KRISTIN ESTATES

PCD FILE NO.: SF2521

FINAL PLAT
KRISTIN ESTATES

KRISTIN ESTATES

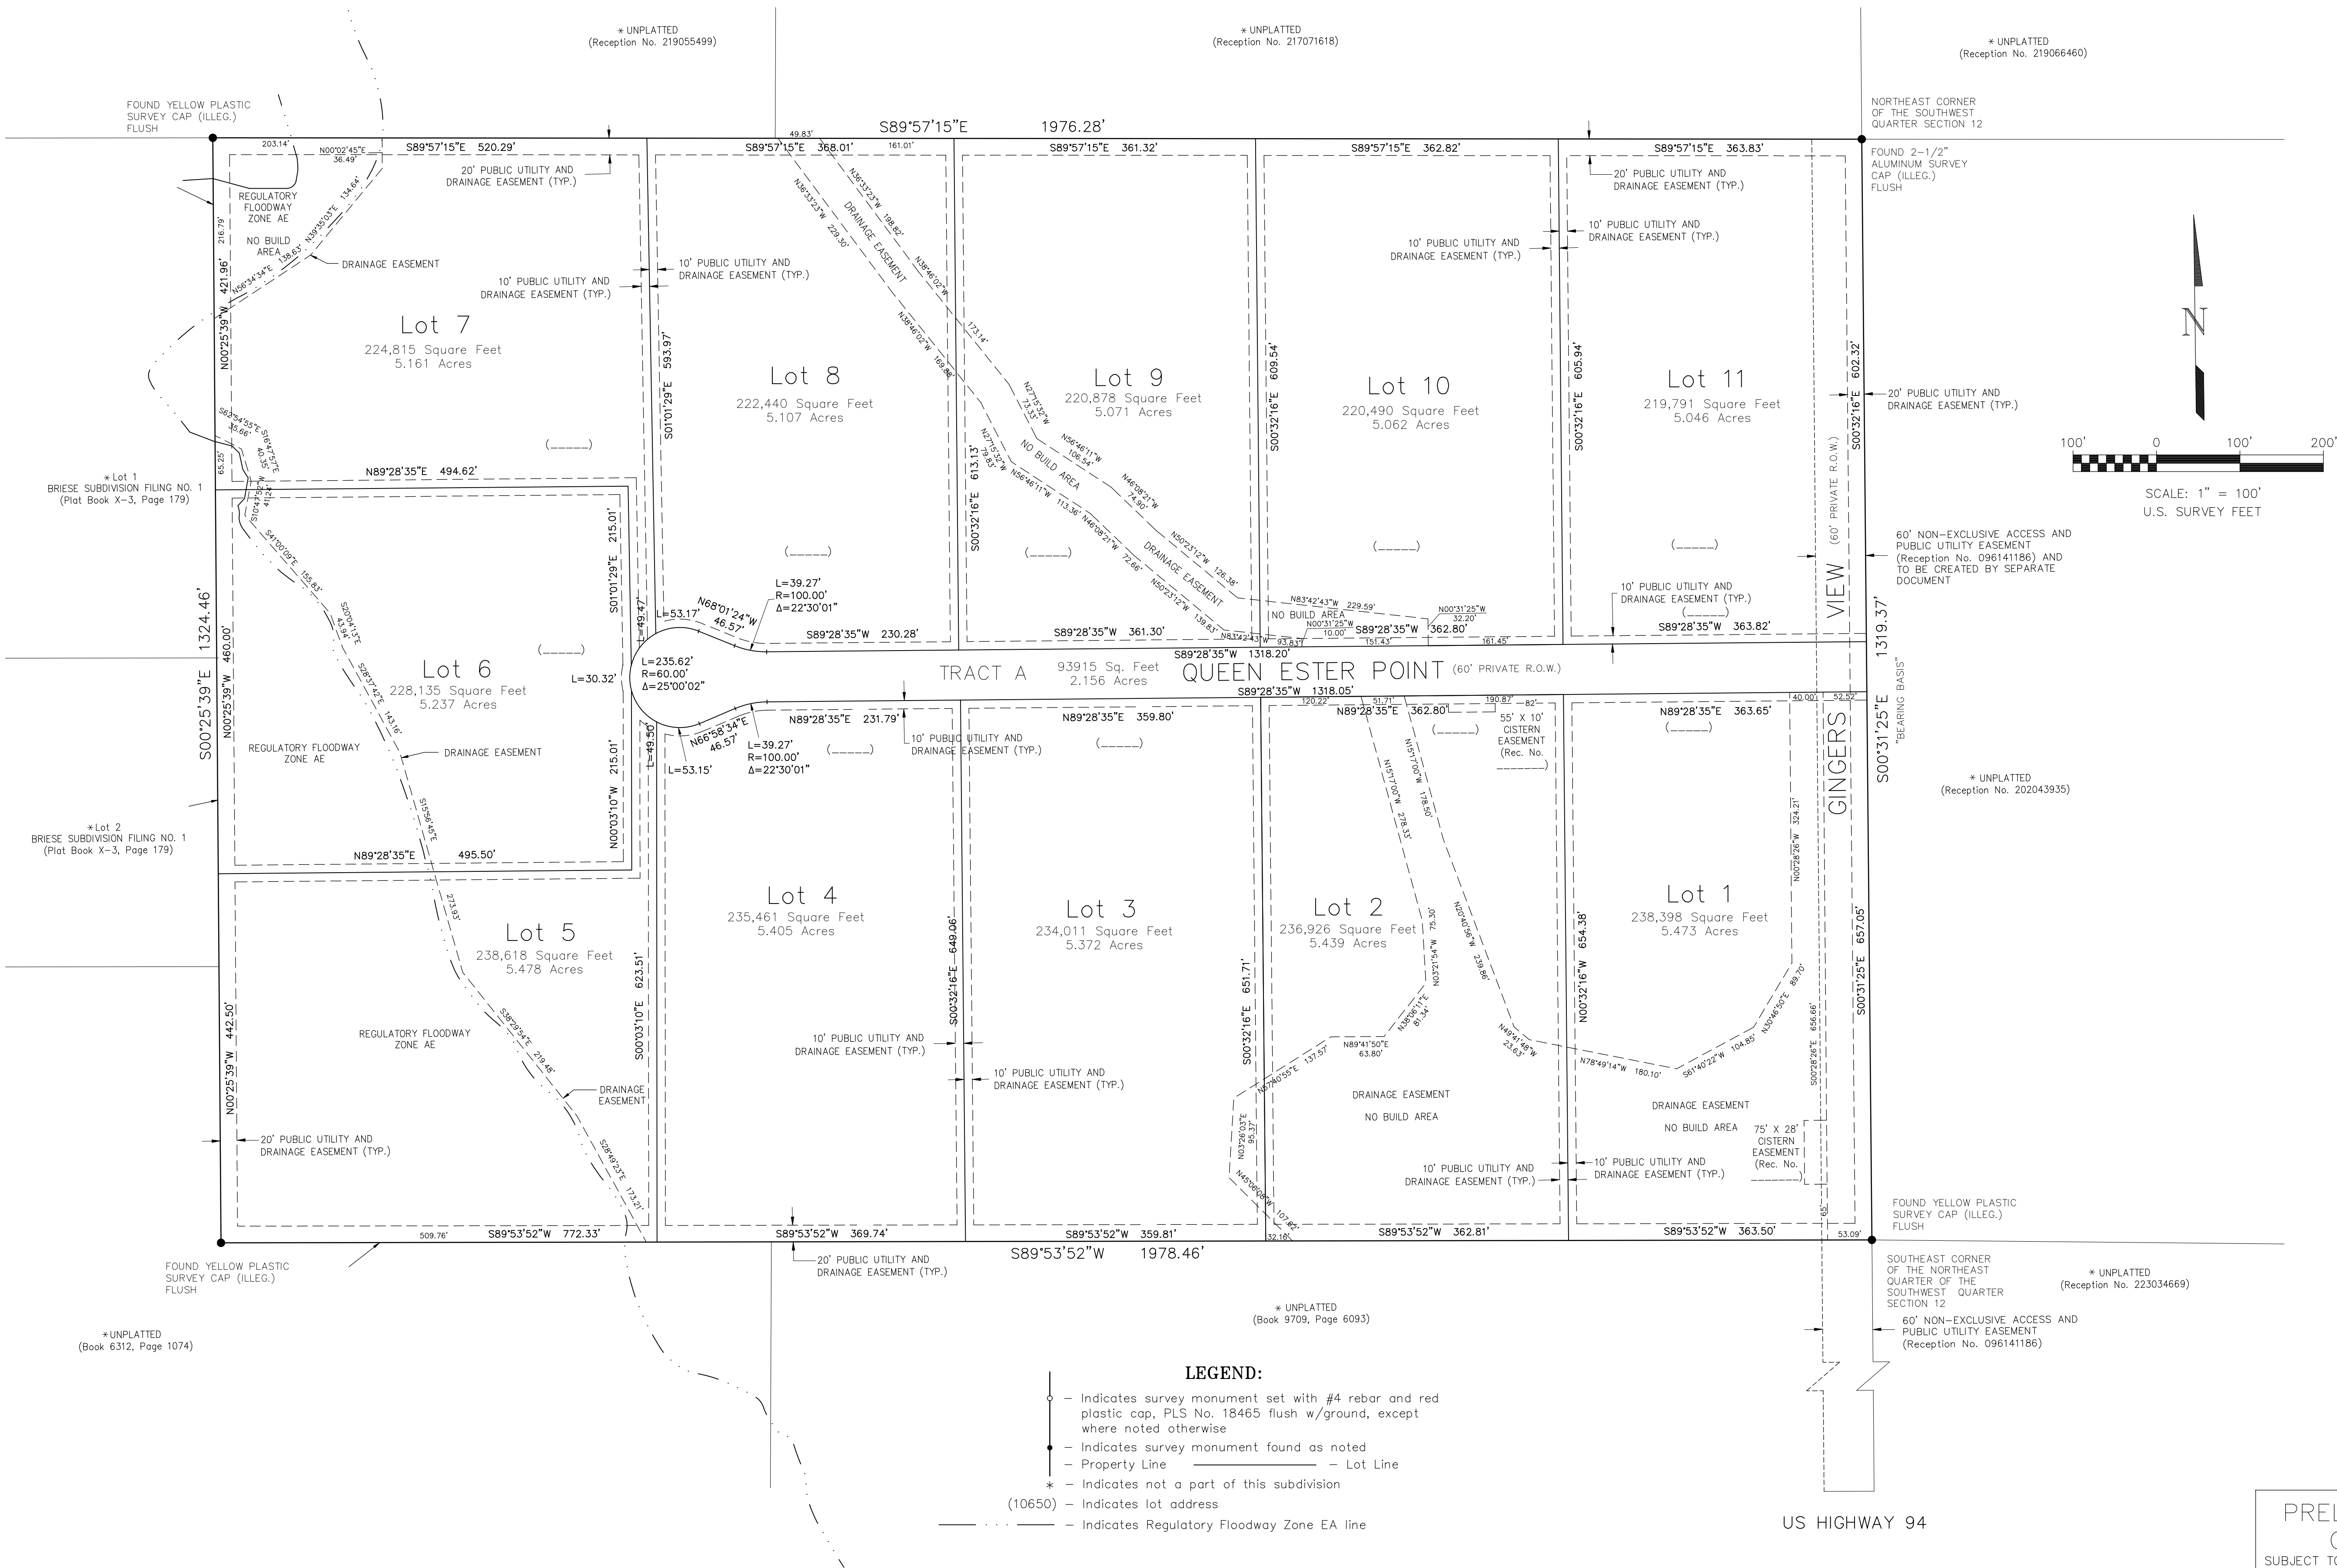
Add a note to the plat acknowledging that per ECM Section I.7.1.B.5, the residential lots impervious area may not exceed 10 percent unless a study is prepared in compliance with the requirements laid out in the above ECM Section and the impervious area may not exceed 20 percent. This impervious area for each lot must include the proposed driveway. Clarify if this criteria applies to all lots, and list lot numbers where it does not apply.

V1 Comment:
Gas and Electric:
The subdivider/developer is responsible for extending utilities to each lot, tract or building site.

(Please discuss propane/lack of gas lines etc).

An updated access and maintenance agreement is required for what is shown as Gingers View. The agreement will include all neighboring property owners who take access from Gingers View. Include a note with a blank for the reception number. Please record agreement prior to final plat recording.

Please add a specific plat note regarding cistern ownership, maintenance, access etc. z

Add the following notes (unresolved review 1 comment):

"The Upper Black Squirrel Creek Groundwater Management District requires that any groundwater discharged to the surface or into an underdrain system must be infiltrated back into the ground. It is the developer's responsibility to comply with the UBSC district requirements."

Absorption field must be located a minimum of 100 feet from any well, including those on adjacent properties.
Absorption fields must also be located a minimum of 50 feet from any drainages, floodplains, or ponded areas and 25 feet from dry gulches."

V1 Comment: Please remove.
